**From:** Planning  
**Sent:** 20 January 2024 13:55  
**To:** DC Support  
**Subject:** FW: Ecology Consultation Response - 23/03366/OUT

**From:** Megan Belanger <Megan.Belanger@Cherwell-DC.gov.uk>  
**Sent:** Friday, January 19, 2024 5:17 PM  
**To:** Lewis Knox <Lewis.Knox@Cherwell-DC.gov.uk>  
**Cc:** Planning <Planning@Cherwell-DC.gov.uk>  
**Subject:** Ecology Consultation Response - 23/03366/OUT

Illustrative Location of Potential Biodiversity Net Gain Provision

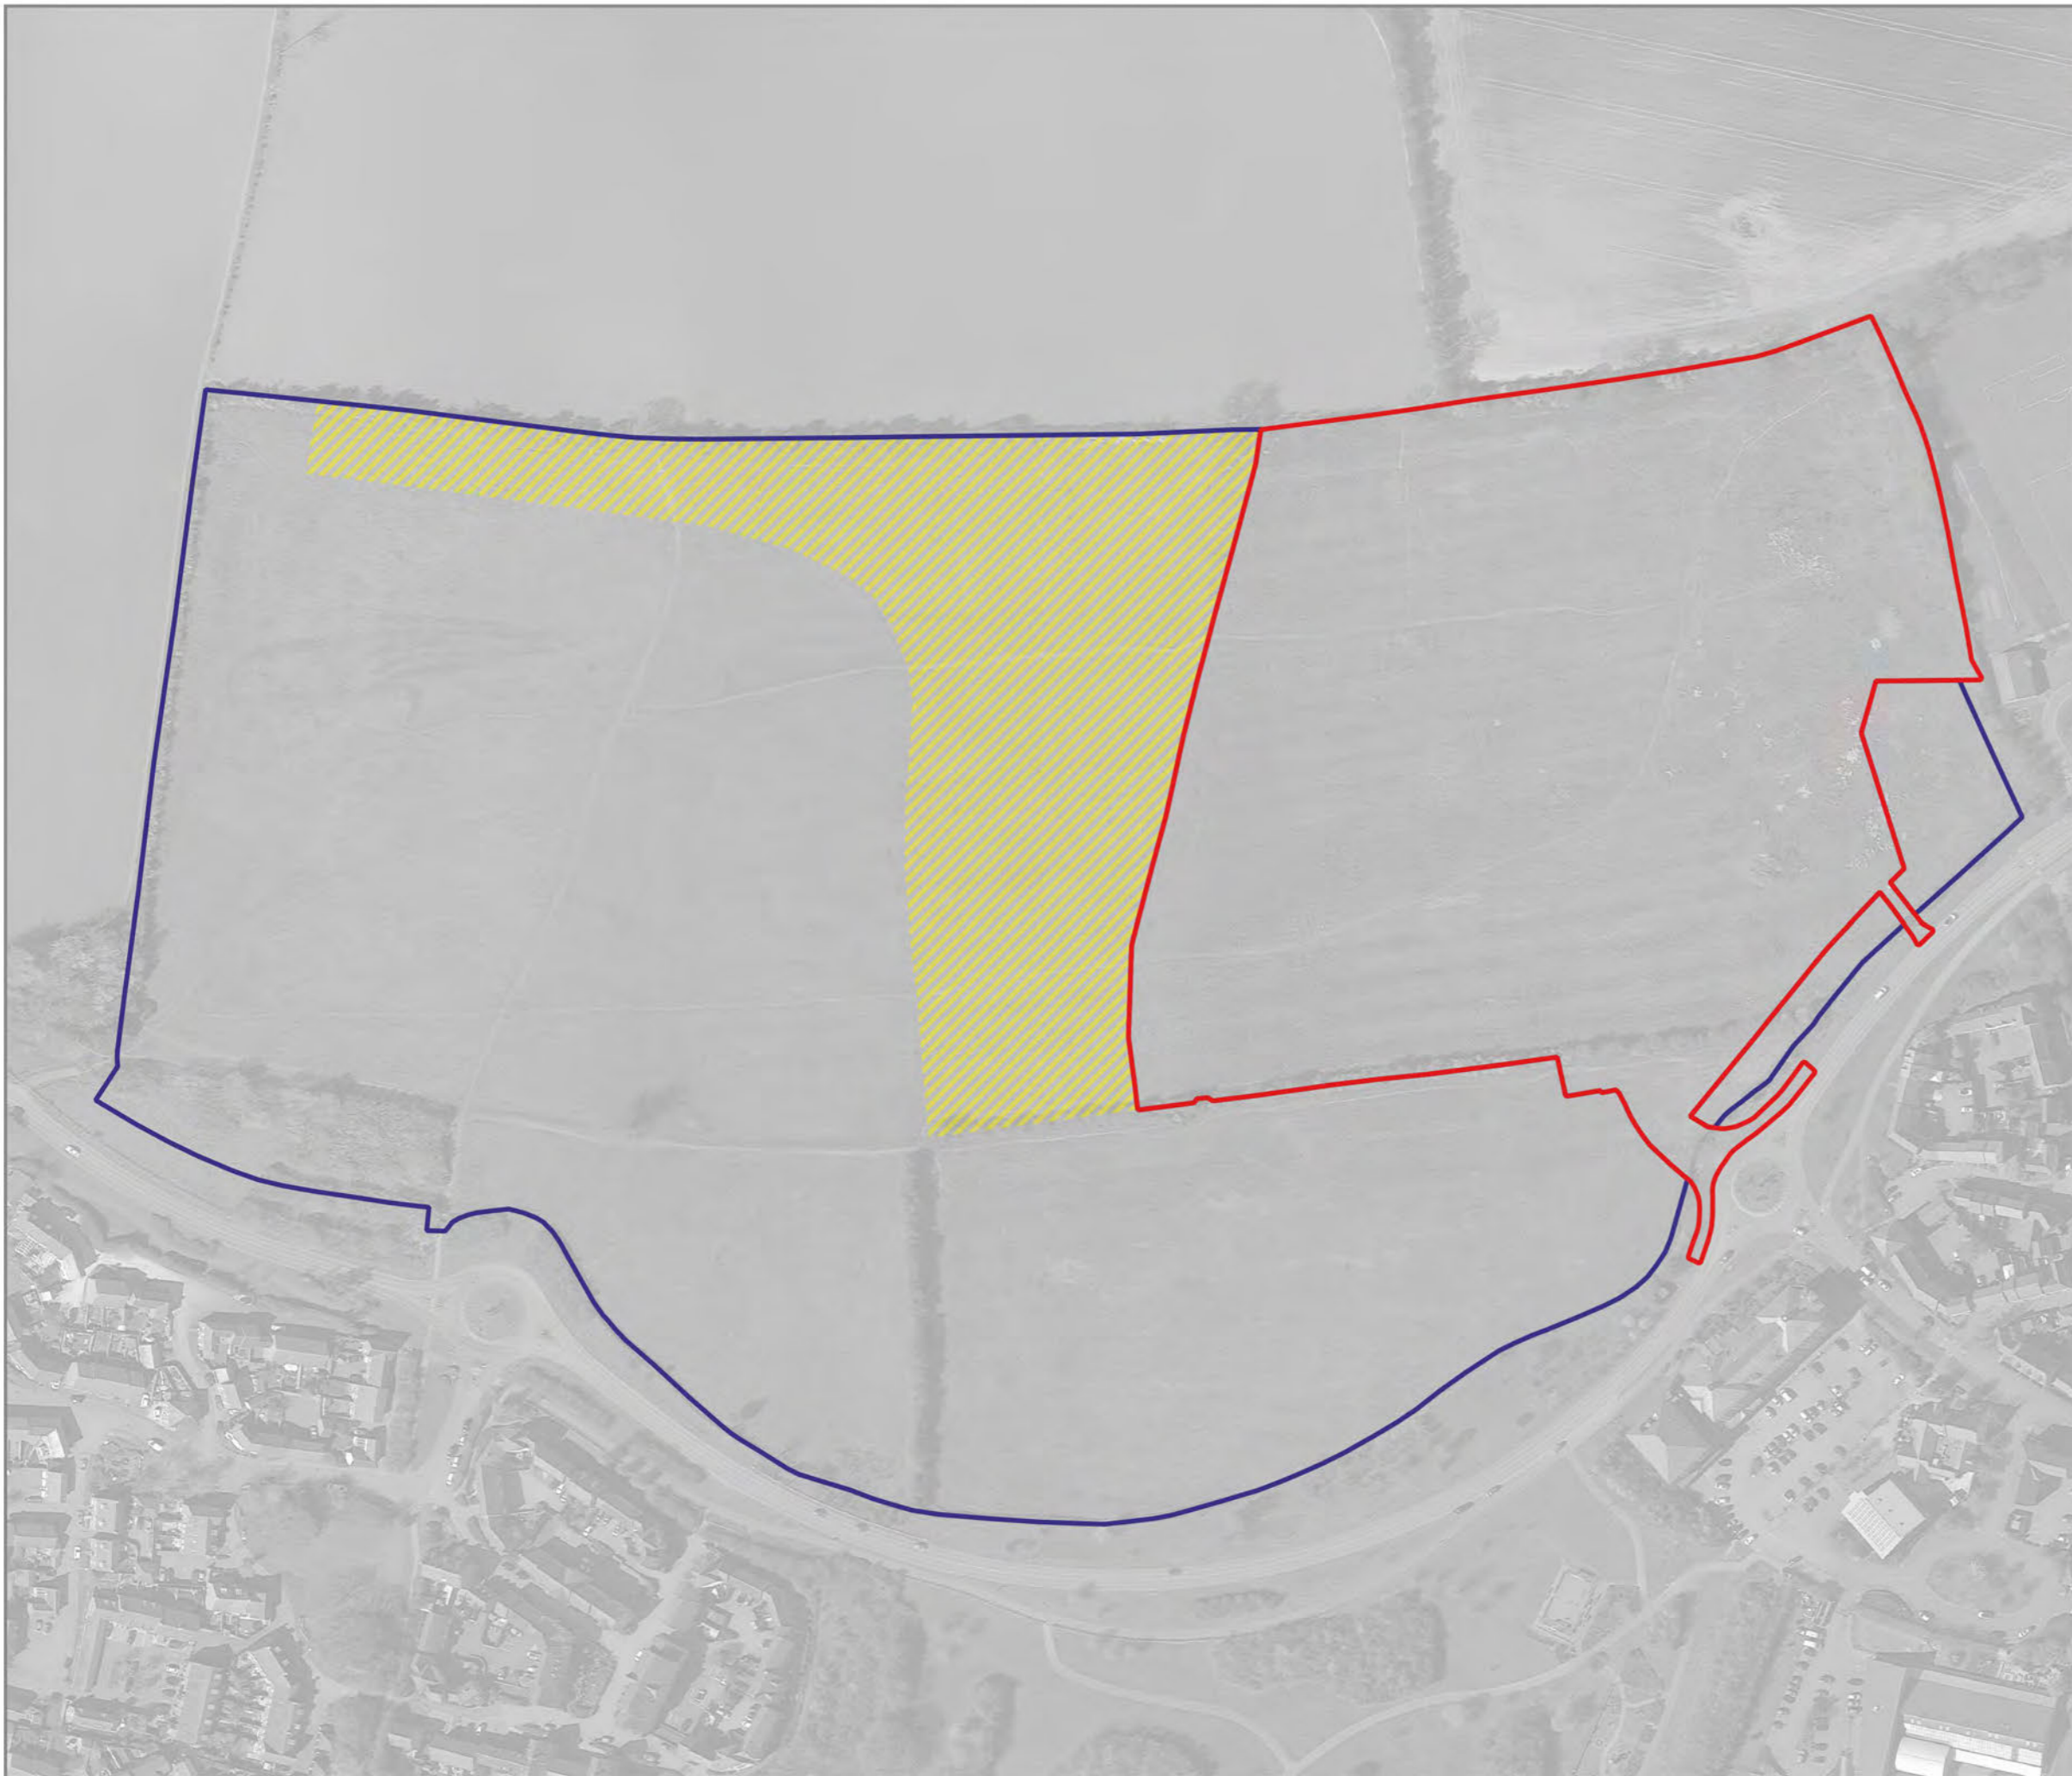
The screenshots of the metric provide an overview of the site and show how 10% is achievable (through on and off-site enhancement), however, the actual metric should be submitted so that I can ensure it was completed correctly. I am concerned about the land being used for on-site migration. The surrounding land is being developed and I am not sure what agreements are in place to ensure that the on-site habitat enhancement will be secured long term. Managing the site as a dedicated nature reserve is one welcome approach.
